Response to Submission comments for Powerhouse Ultimo Renewal (SSD-32927319)

The proposed SSD affects the State Heritage Register (SHR) items, Ultimo Powerhouse (SHR no 02045) and former Ultimo Post Office buildings (SHR No 00502).

12 October 2022

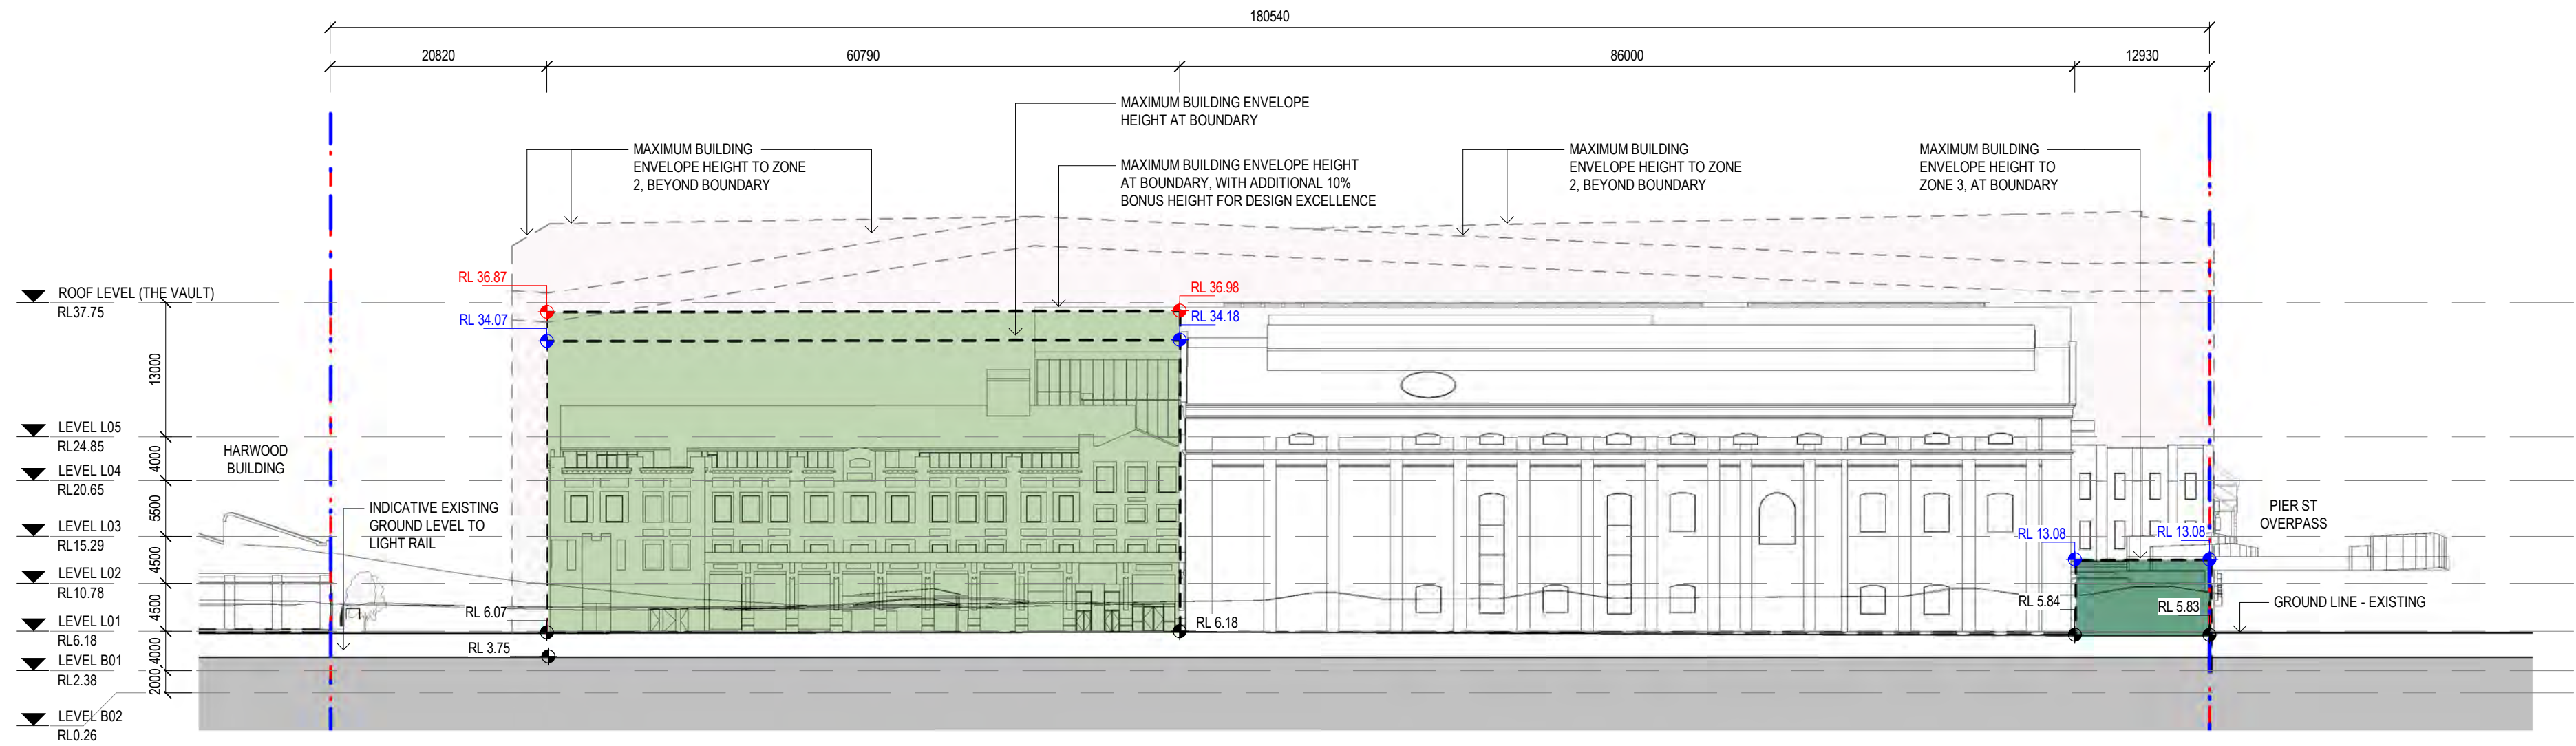
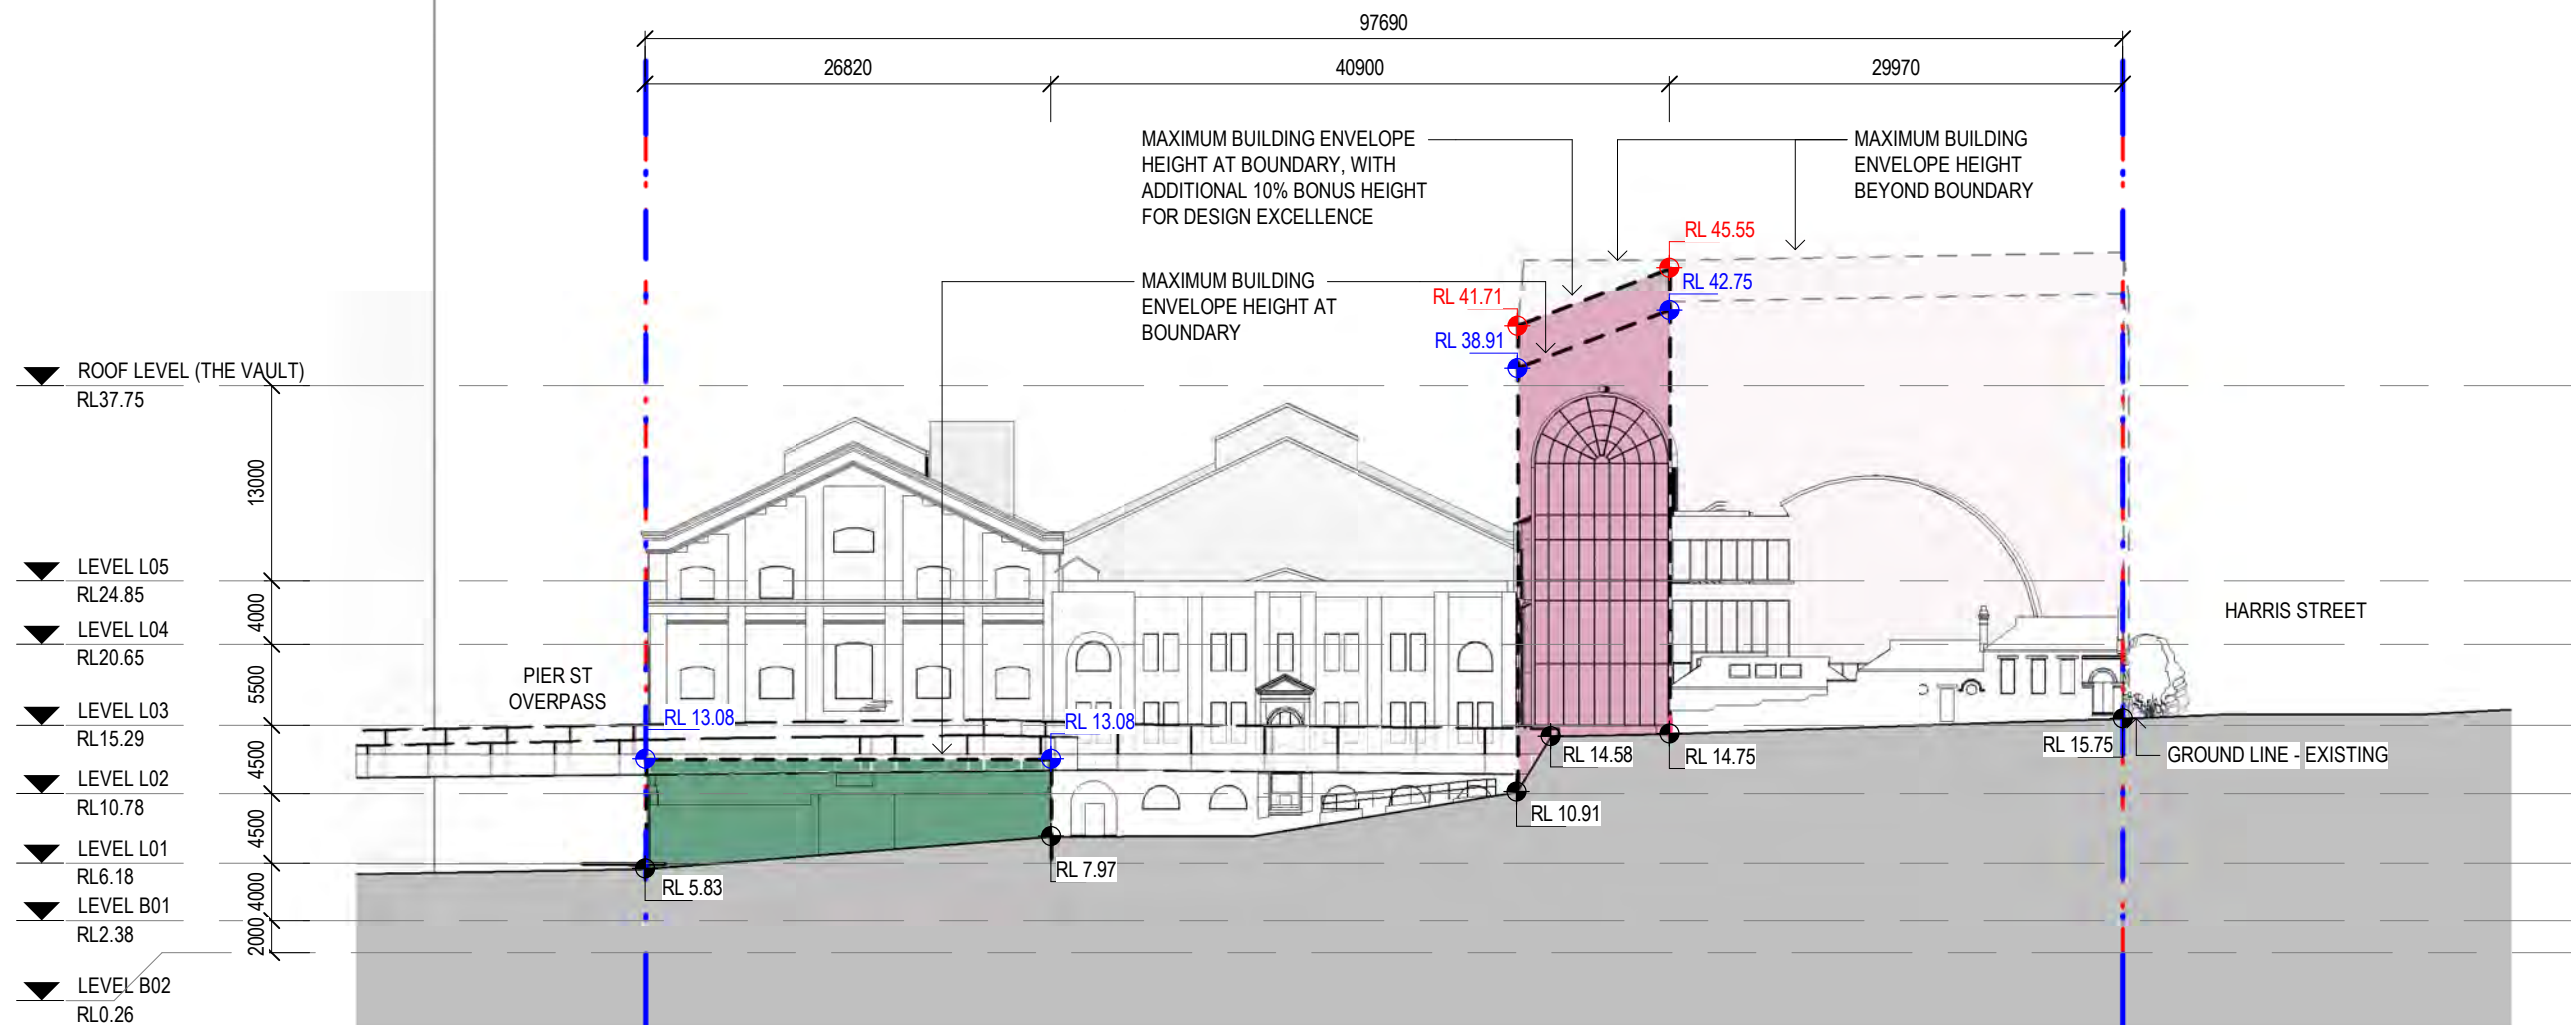
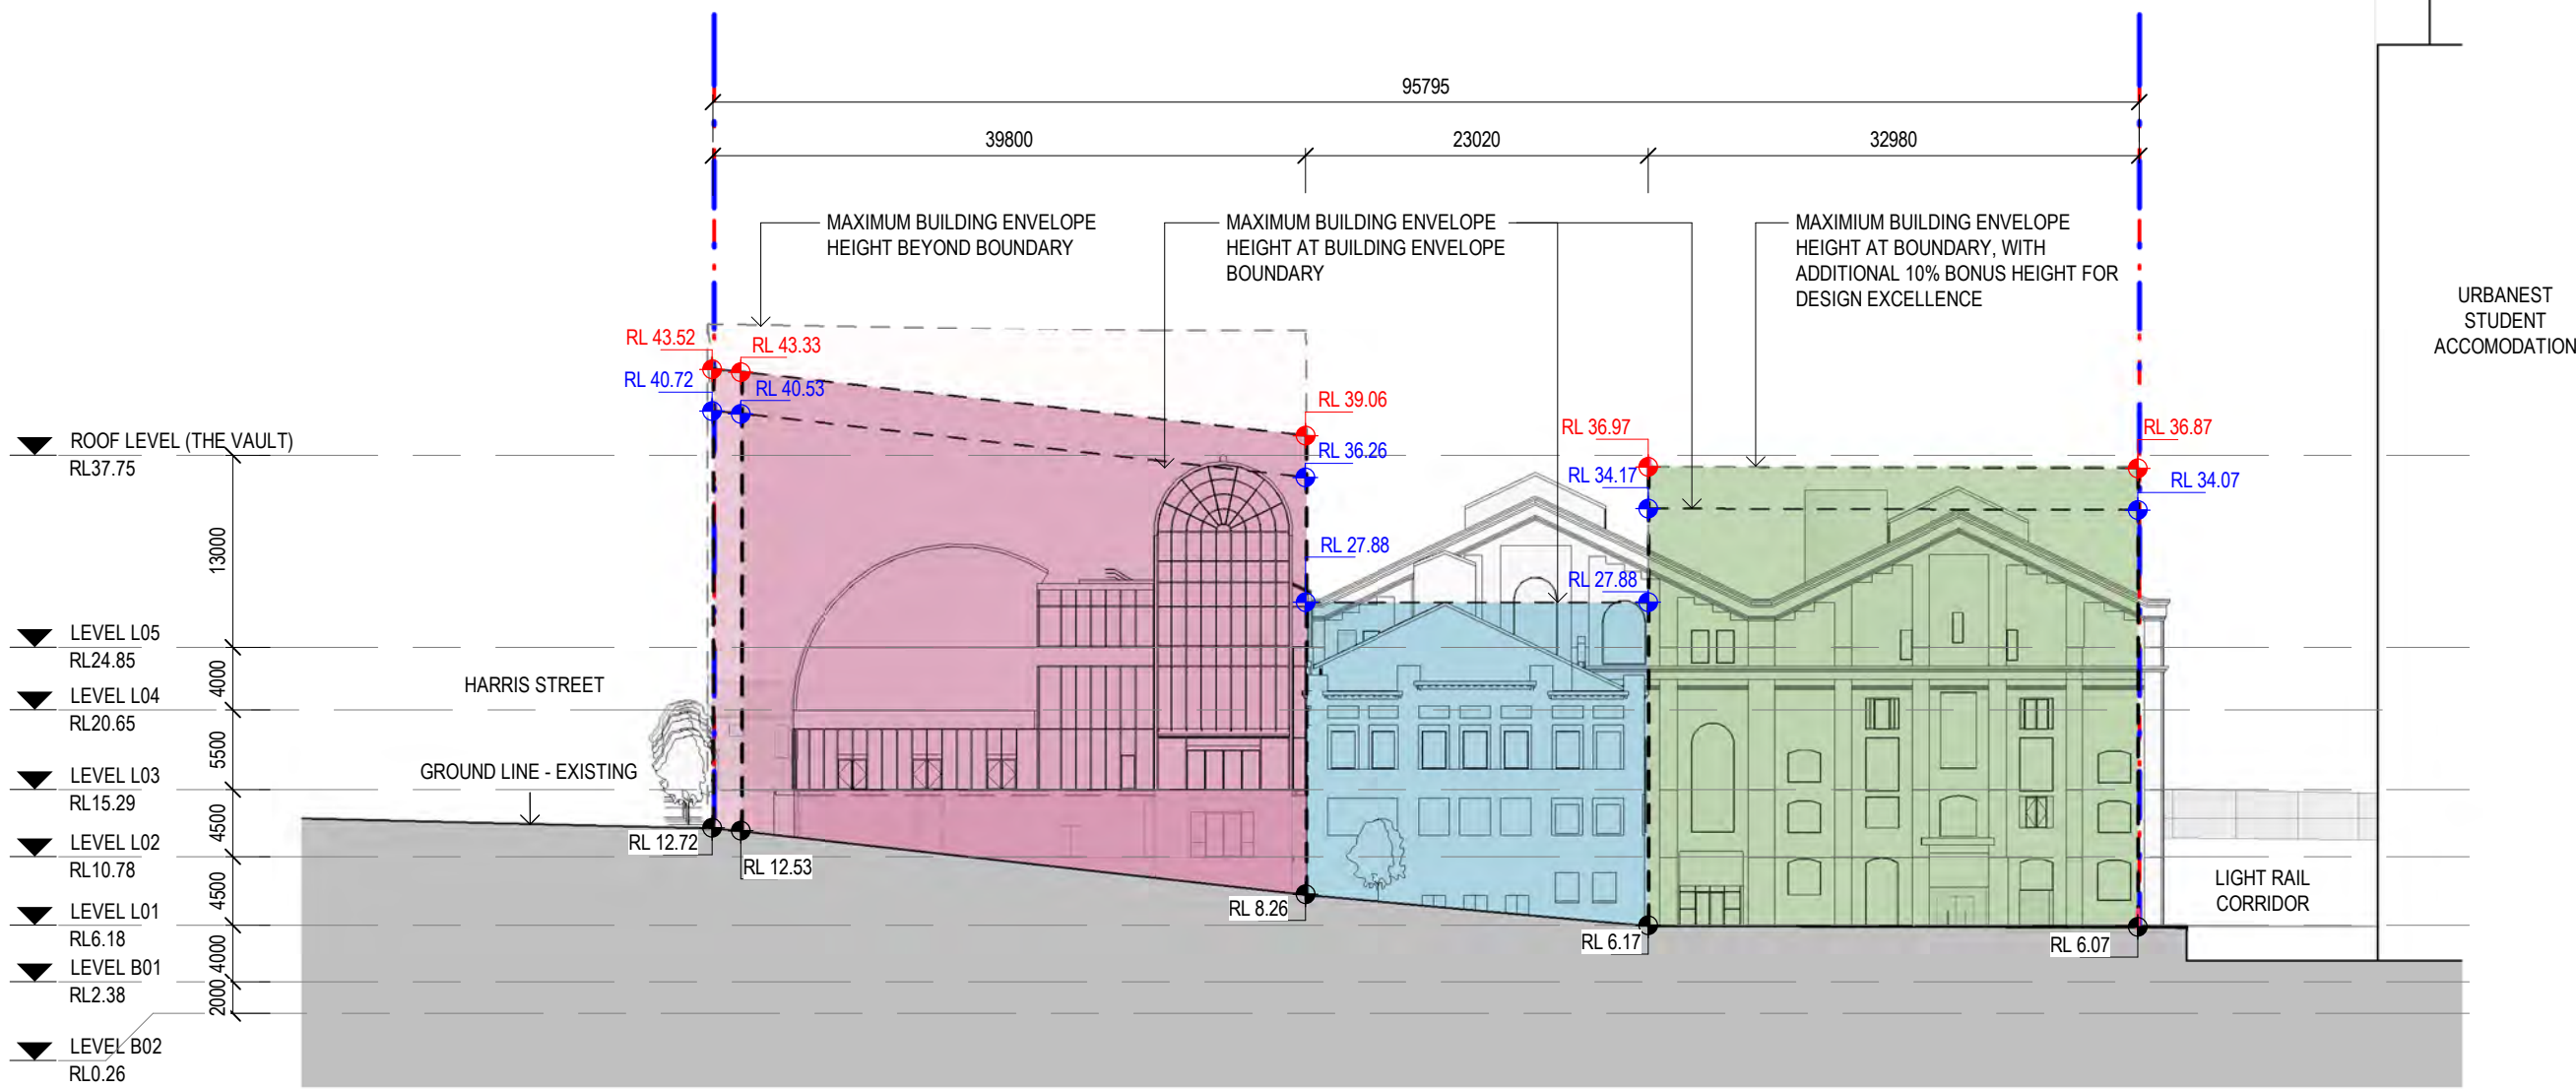
- The separation of the Switch House into a separate zone to allow a possible extension above is noted. While the proposed building envelope above the Switch House has been revised, it is recommended that any future works are mindful of historic fabric and character of the building. Any proposed extensions should be designed to be recessive and represent a clear articulation or transition between the historic core and any contemporary intervention. It is considered that any amendments and possible alterations to fabric within and above the Switch House would require a detailed assessment against impacts to the significant values and fabric during the Stage 2 Detailed SSDA.
